**Our ref:** 25\_32486\_P

**Your ref:** H09-0442-25

**Site Location:** Land off Battlefields Lane South  
Holbeach Spalding PE12 7PG

**Summary of Proposal:** Hybrid Application  
for 158 Dwellings Comprising:- Full  
Application for the Erection of 62 Dwellings,  
Associated Landscaping and Infrastructure  
and Outline Application for the Erection of  
Approximately 96 Dwellings (Some Matters  
Reserved)

Title:
**DRAINAGE STRATEGY
SHEET 6 OF 7**

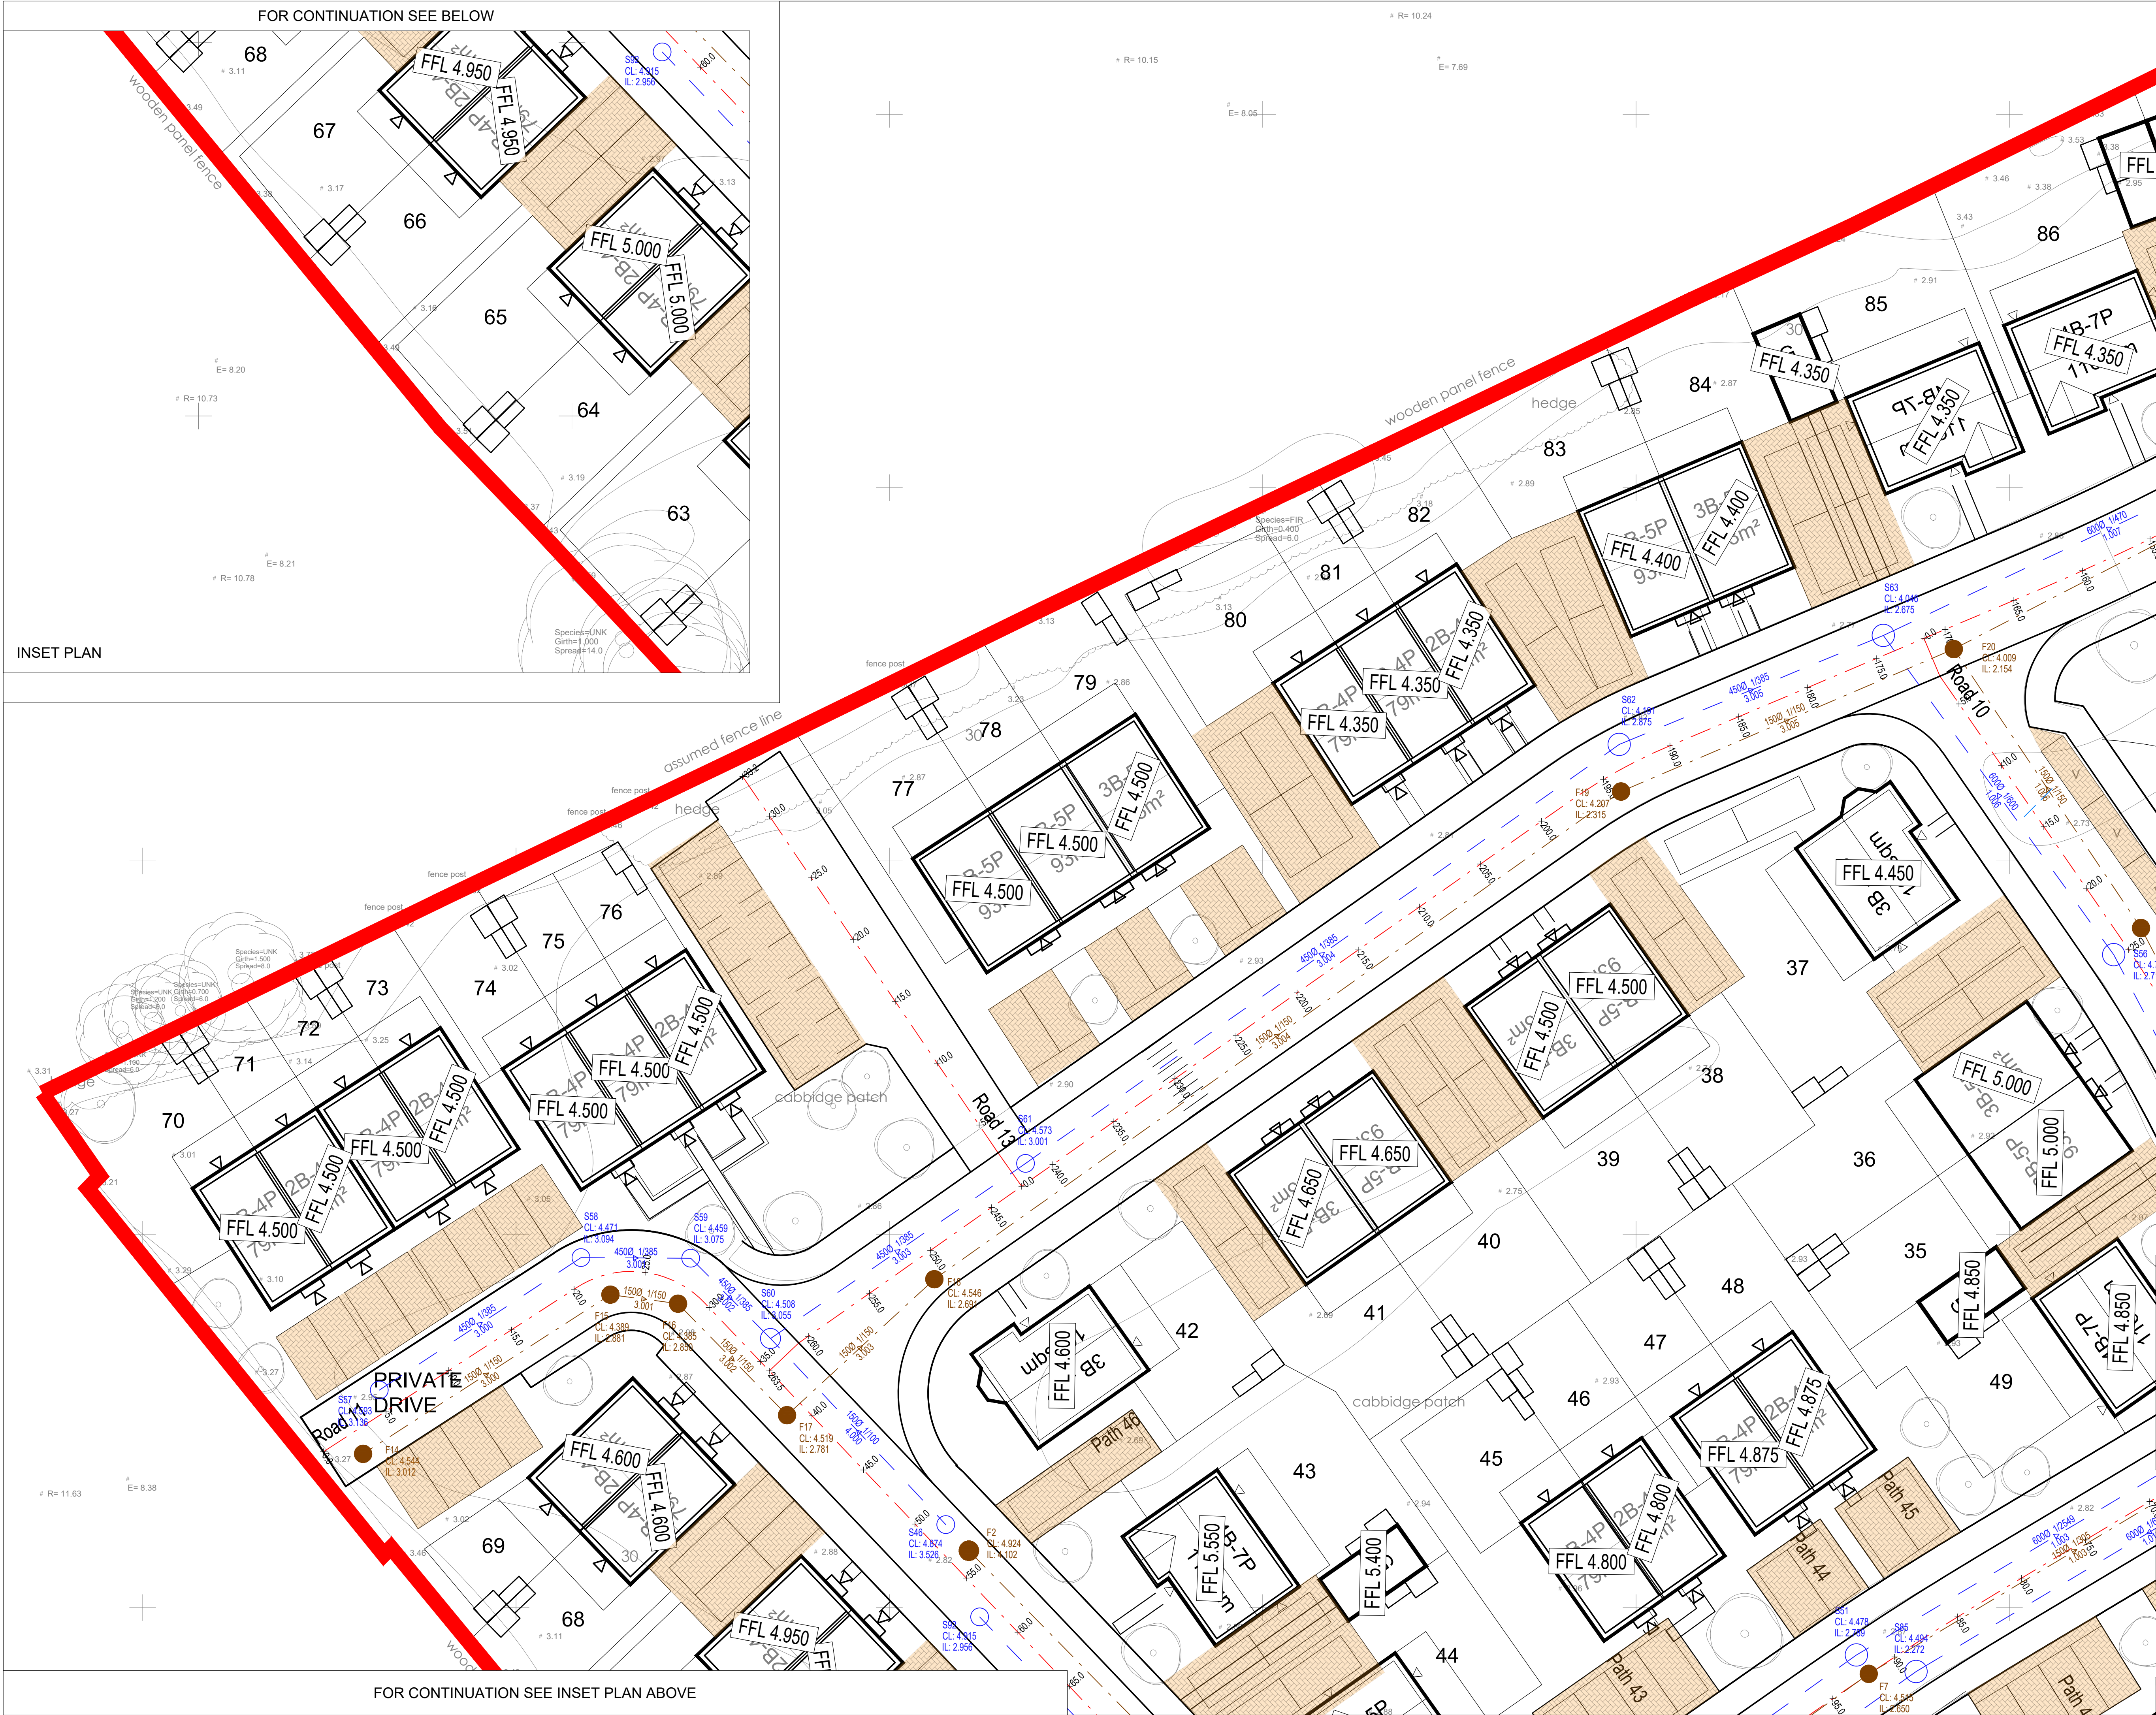
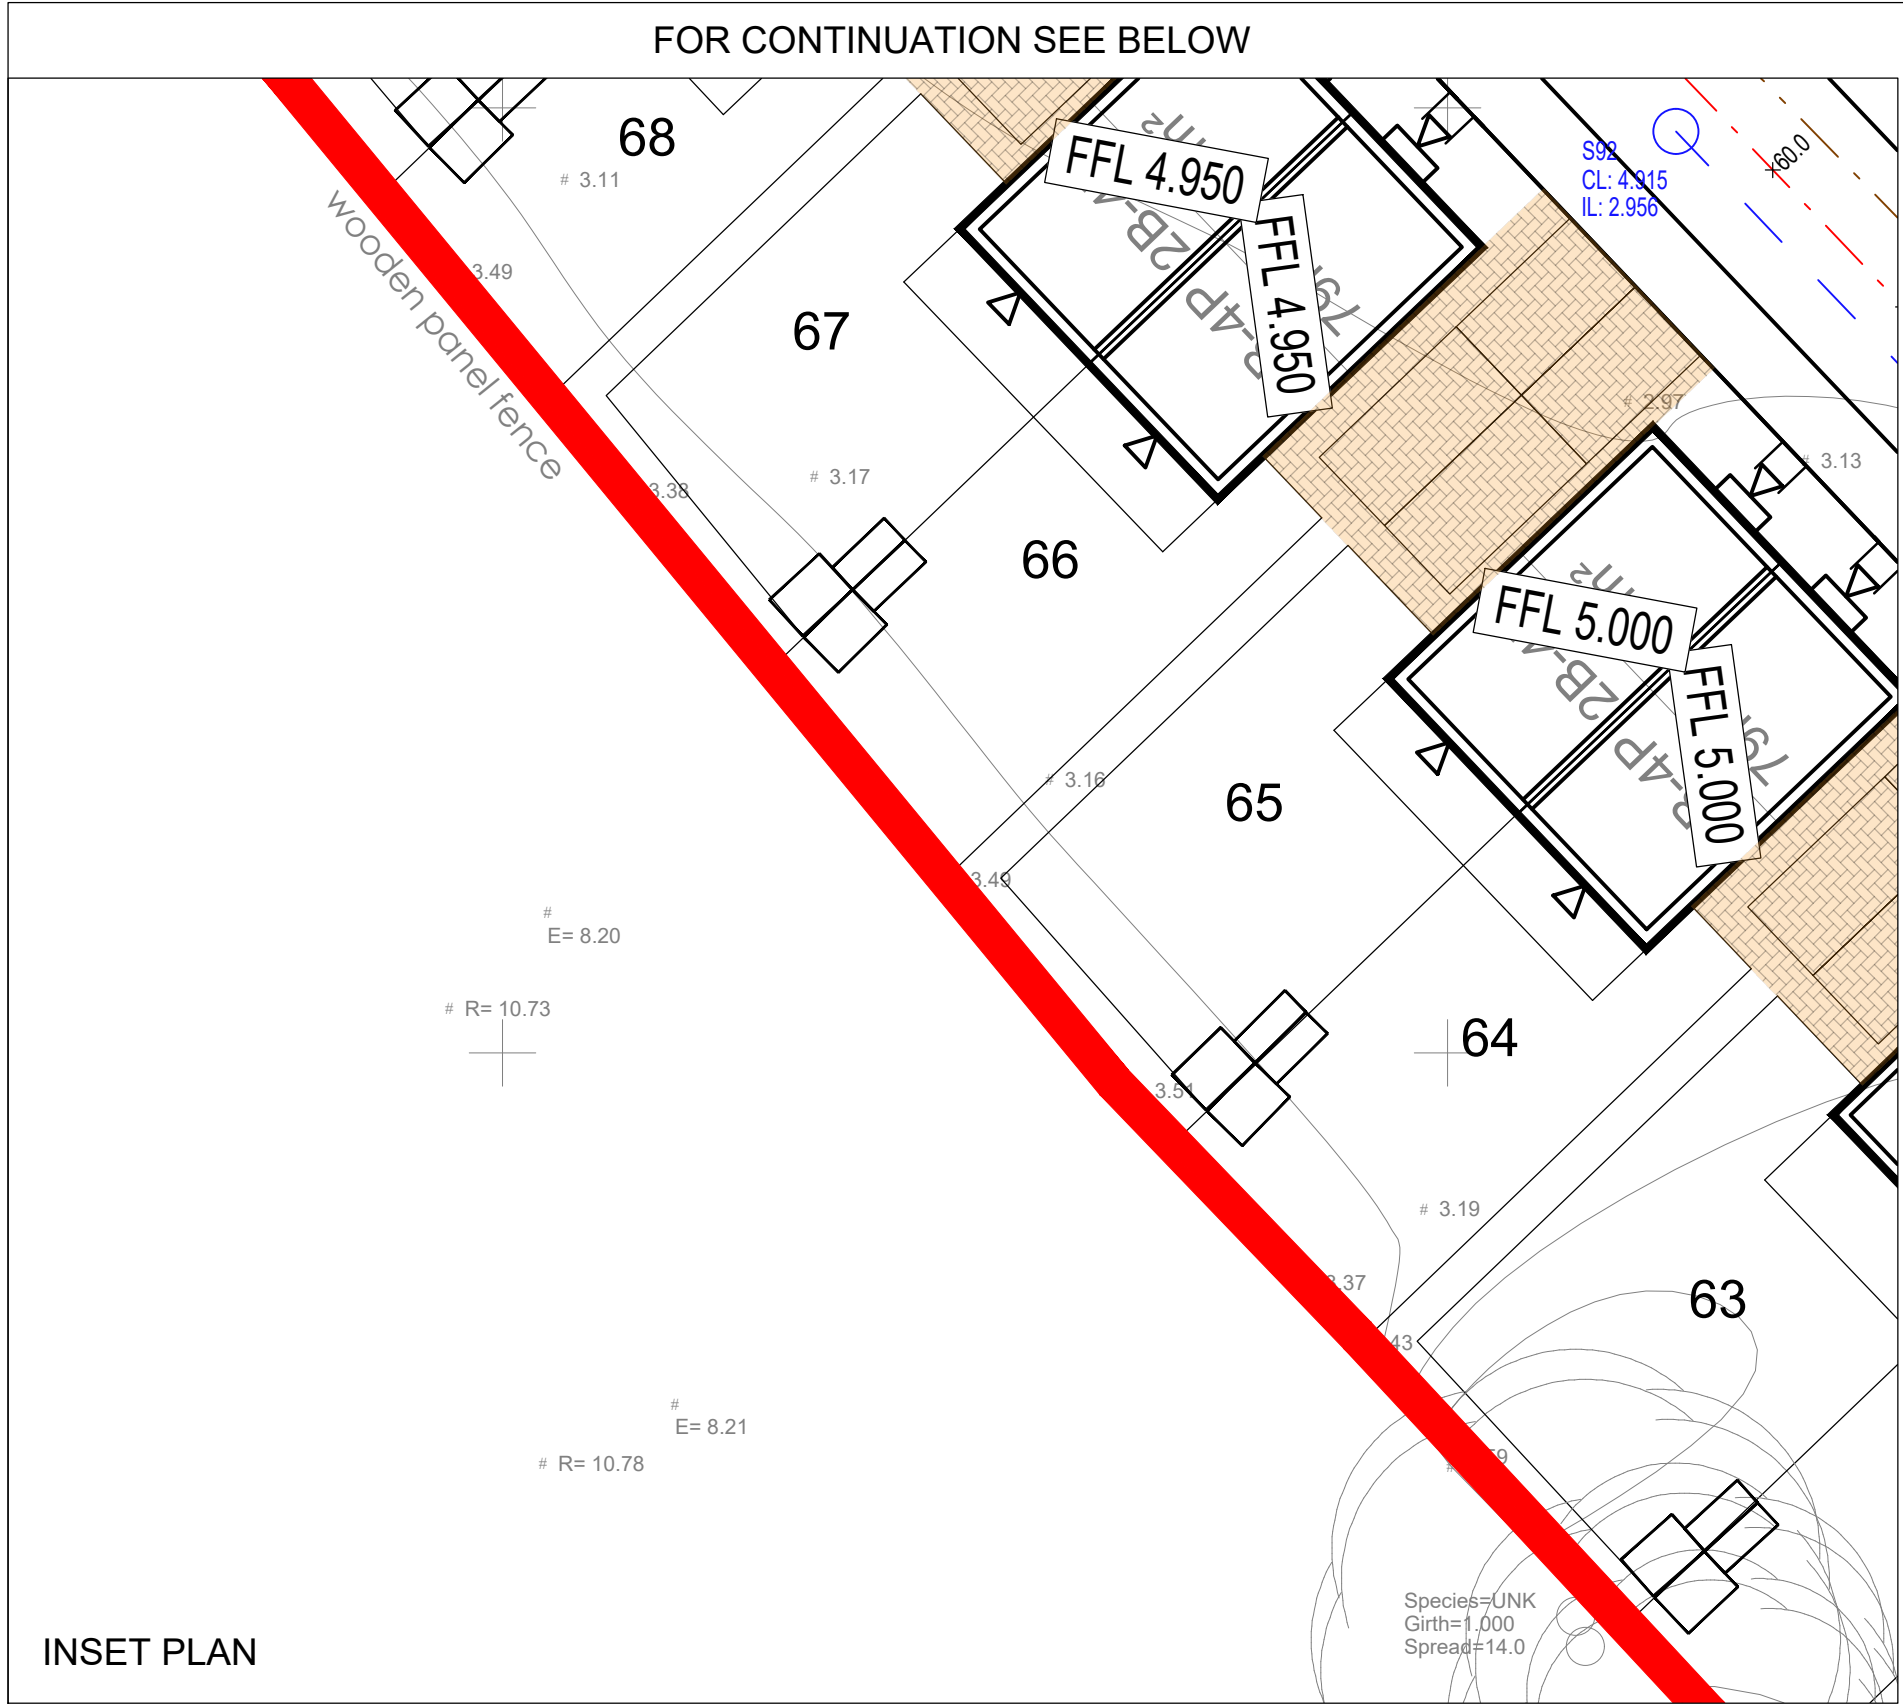
The applicant proposes to discharge surface water at a rate of 2.7 l/s to an Anglian Water Sewer for Phase 1 and 3 l/s to the Board arterial watercourse for Phase 2. Please see the Board's comments below:

2. It is not clear whether the surface water discharge from Phase 3 has been included in the discharge rate proposed for Phase 2. Please can the applicant confirm whether the discharge rate specified within Phase 2 includes the impermeable areas created from Phase 3?

3. The applicant has specified within the Flood Risk Assessment (087.5018/FRADS/2 Including Drainage Strategy - October 2024) that the discharge rate will be limited to greenfield rates for the site's developed area. Please can the applicant confirm what 'the developed area' refers to? Does the developed area include both permeable and impermeable areas? The Board requests that any proposed discharges into our system are reduced to the QBar rate for the impermeable areas only. For example, if the total site area is 6.2 ha but the impermeable area for the site totals 1.2ha, the discharge rate should be reduced down to the QBar rate for the 1.2ha of impermeable area only.
